Current Zoning: N1-A (Neighborhood 1-A)
Proposed Zoning: N1-C(CD) (Neighborhood 1-C, Conditional)

Approximately 4.75 acres located east of Moss Road, south of Livingston Mill Road, and north of Scottsman Trace Drive.

The petition proposes to develop a vacant, wooded property in the Steele Creek community with 21 triplex dwelling units.

SITE PLAN, RZP-2025-025

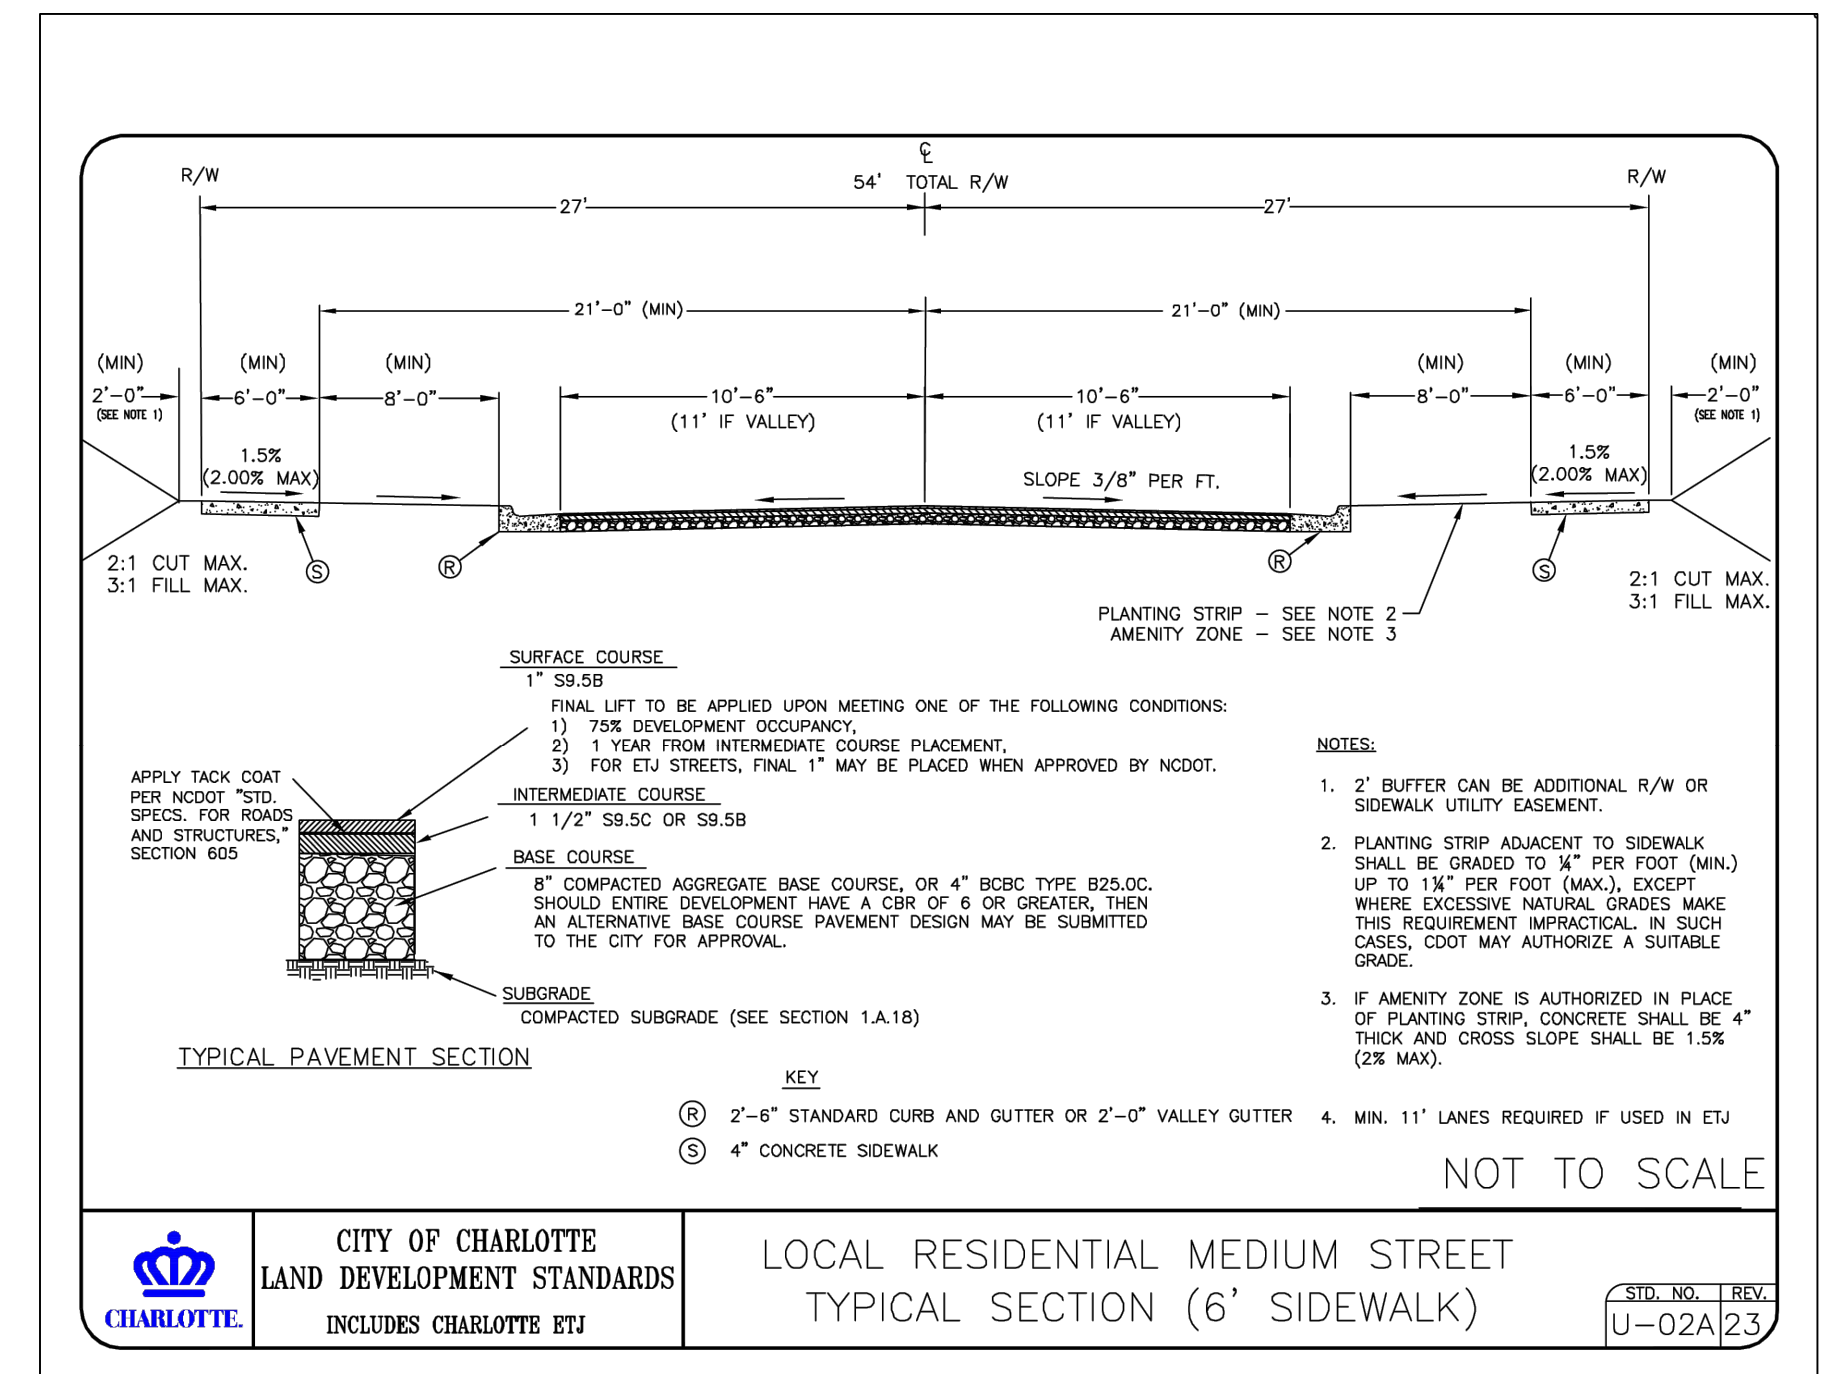
1. ~~Remove all note references to multi-dwelling developments, which are not permitted in the N1-C zoning district.~~ **ADDRESSED**
 2. ~~Revise max building coverage note from 40% to 50%.~~ **ADDRESSED**
 3. ~~Label and dimension front and rear setbacks and lot width.~~ **ADDRESSED**
-
